Addendum No. 1

RE: Contract ID C203143

Rowan County (P-5206A)

SR-2538 (Peeler Road), SR-1560 (Cedar Springs Road) Grade Separation
Over Norfolk Southern/NCRR Railroad

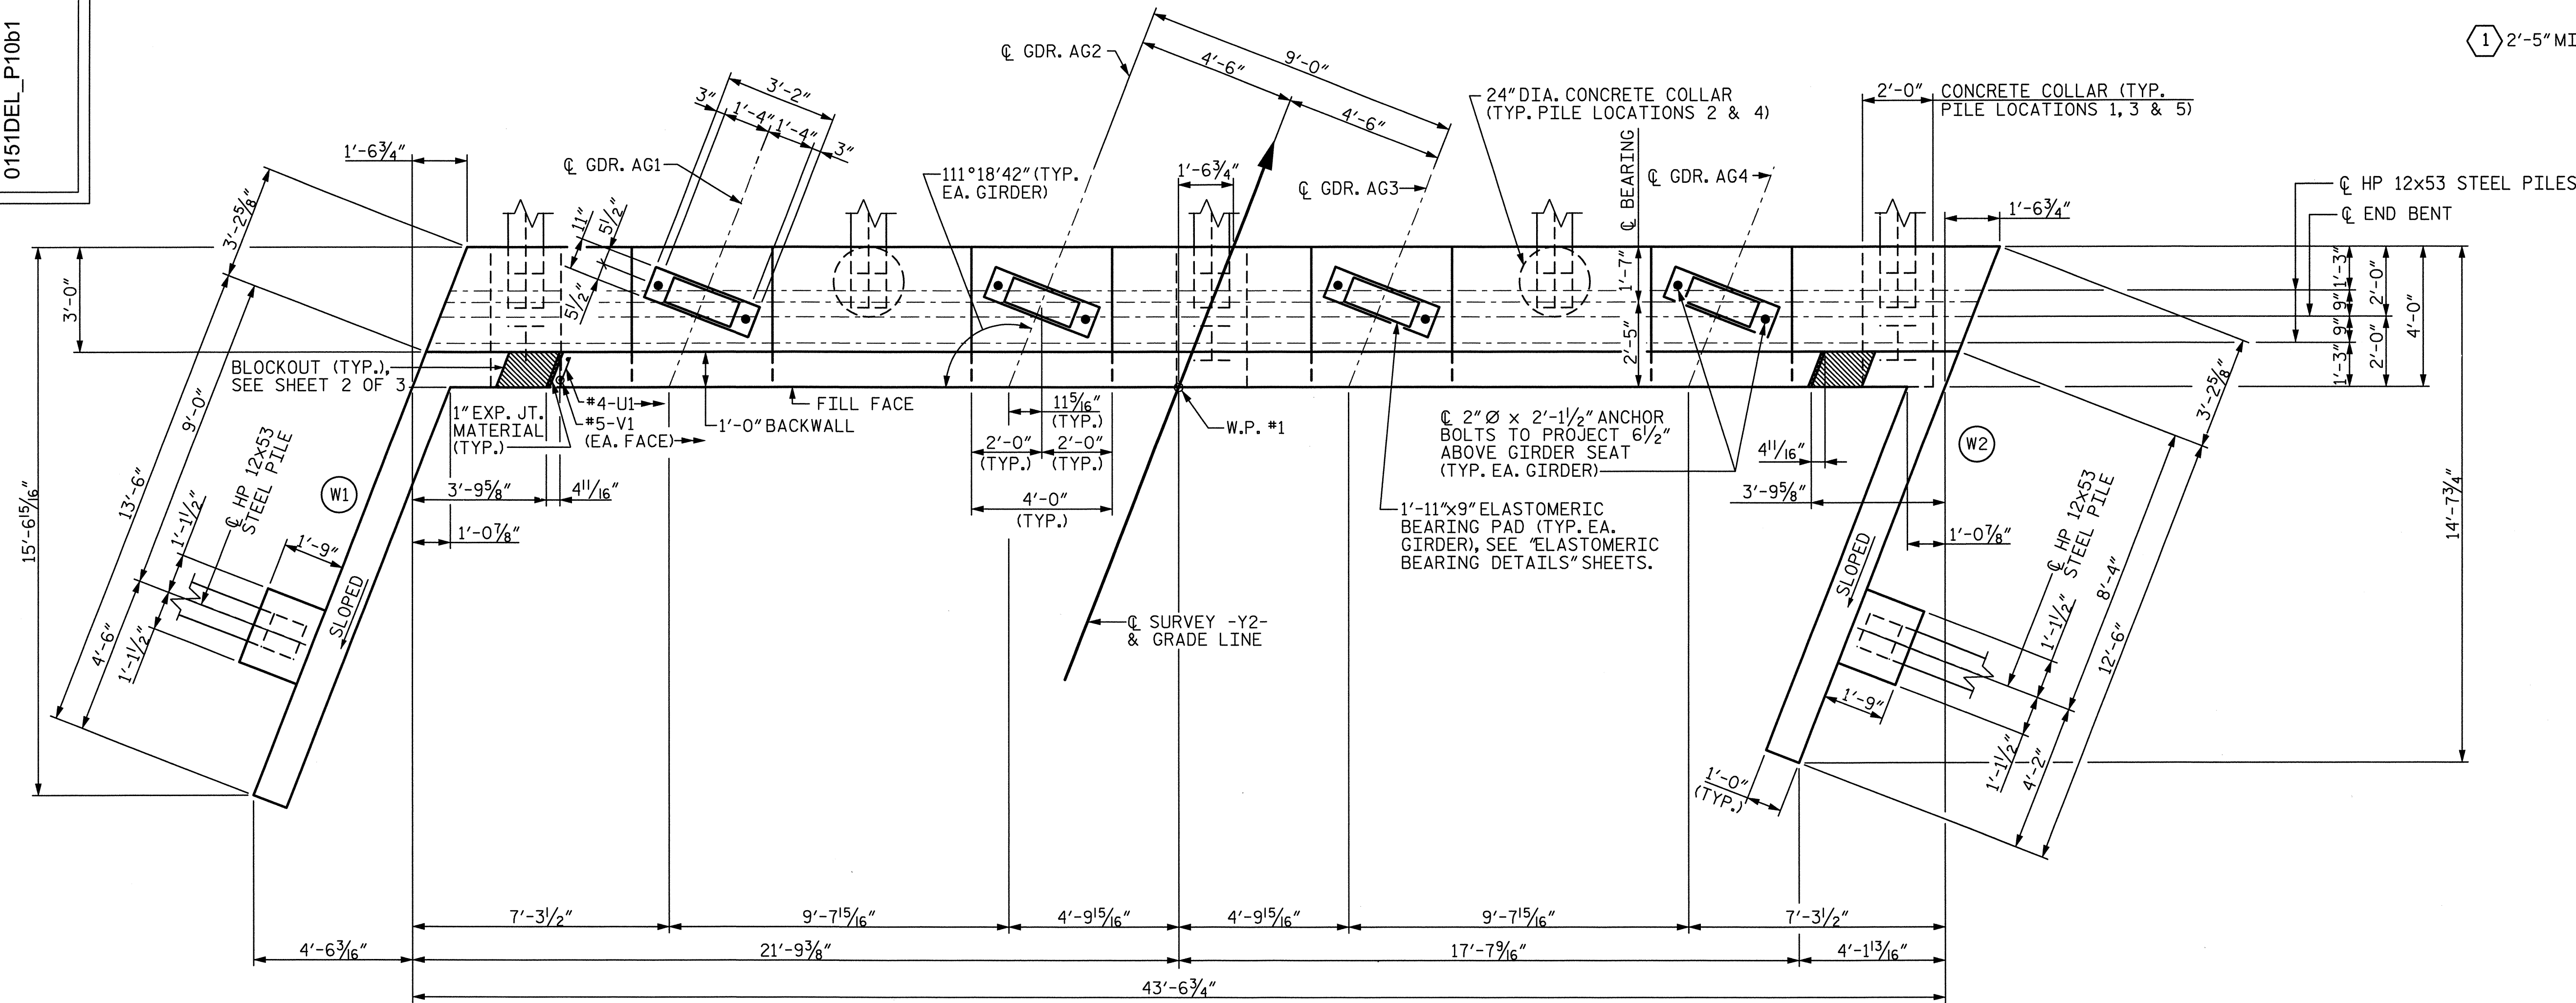
On Sheet No. S-36 the quantity of Class AA Concrete has been revised. Please void Sheet No. S-36 in your plans and staple the revised Sheet No. S-36 thereto.
